# CITY OF PORTLAND BUILDING PERMIT

Job ID: 2011-02-404-ALTCOMM

has permission to Renovate Units B & C, common areas for temporary in-law situation, update insulation, kitchen & basement provided that the person or persons, firm or corporation accepting this permit shall comply with all of the provisions of the Statues of Maine and of the Ordinances of the City of Portland regulating the construction, maintenance and use of the buildings and structures, and of the application on file in the department.

**Jeanie Bourke - Re: 39 cumberland renovation project upgrades**

J11 THIRD FLOOR PROPOSED PLAN

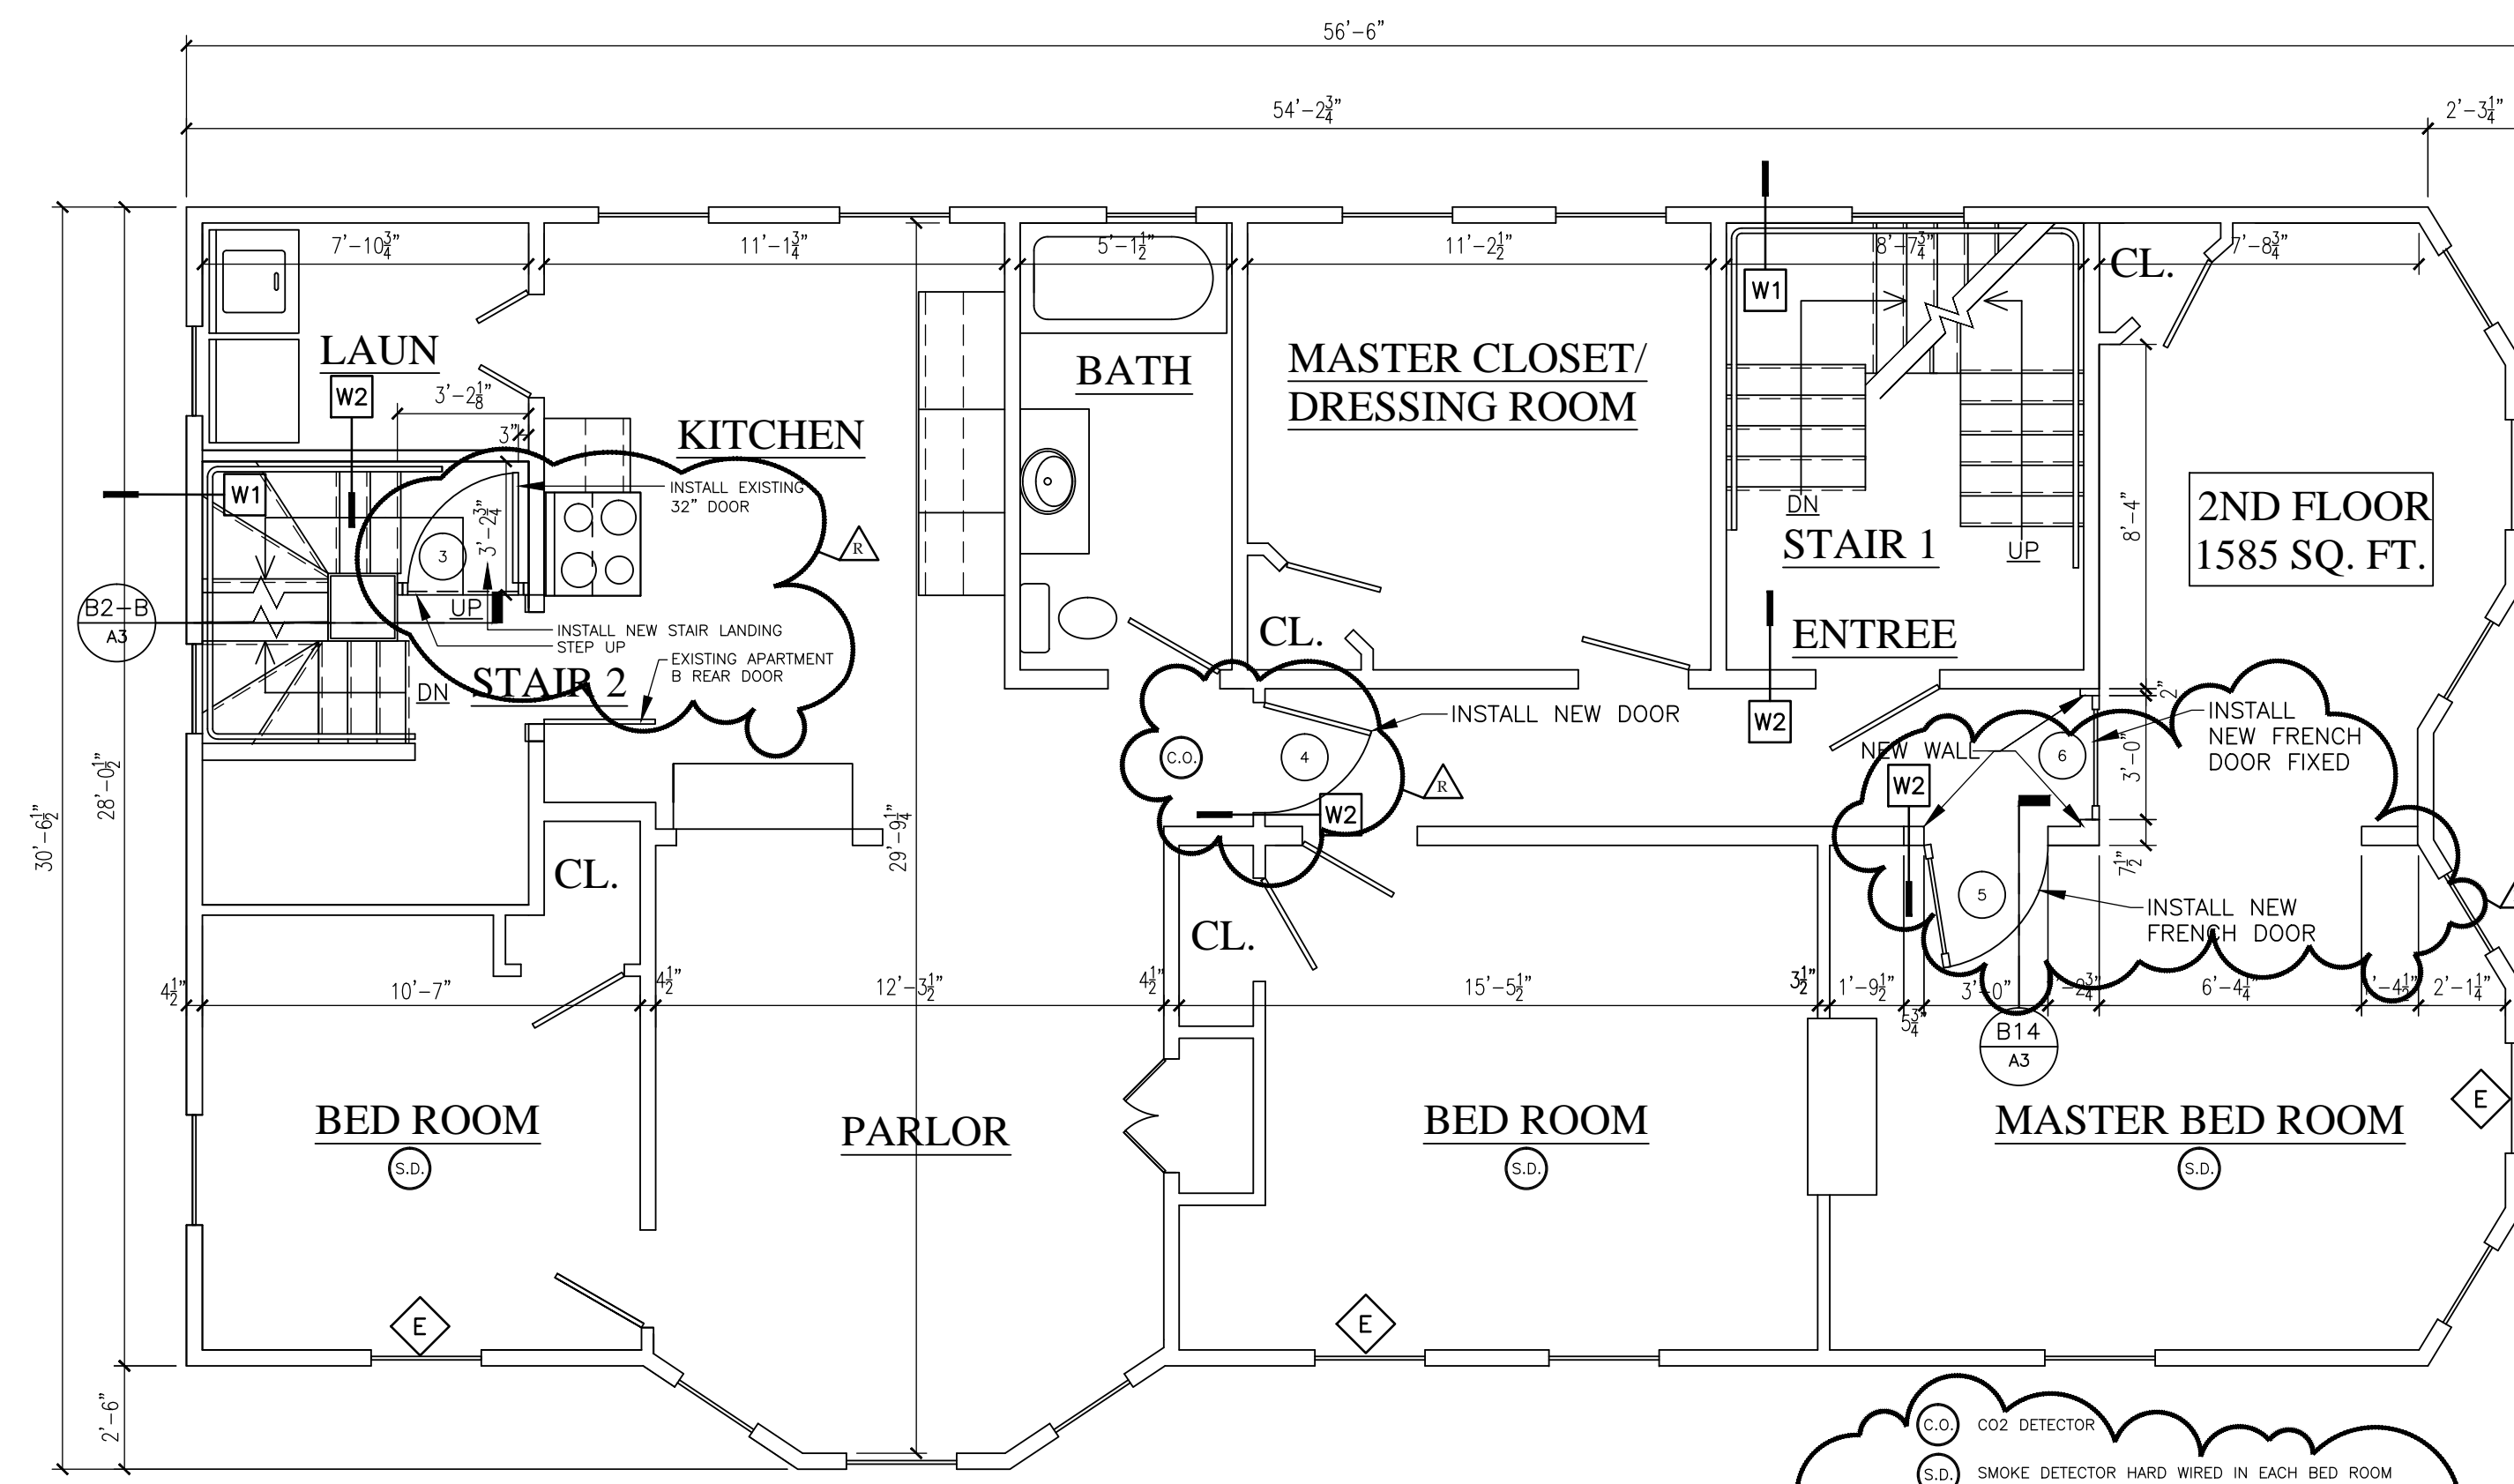
5. This approval allows the relocation of the 3<sup>rd</sup> floor rear door to the 2<sup>nd</sup> floor with the addition of a landing. A modification of IBC Sec. 1008.1.5 Floor elevation allows 1 change of elevation at the door swinging over the landing as similarly allowed in exception 1.

The only item missing that I have on my list is the height of the **relocated door at the new landing**. I believe you stated that this was an error, that the **6'-8"** dimension line should have been from the landing (not the floor) to the header. This email serves as verification of that.
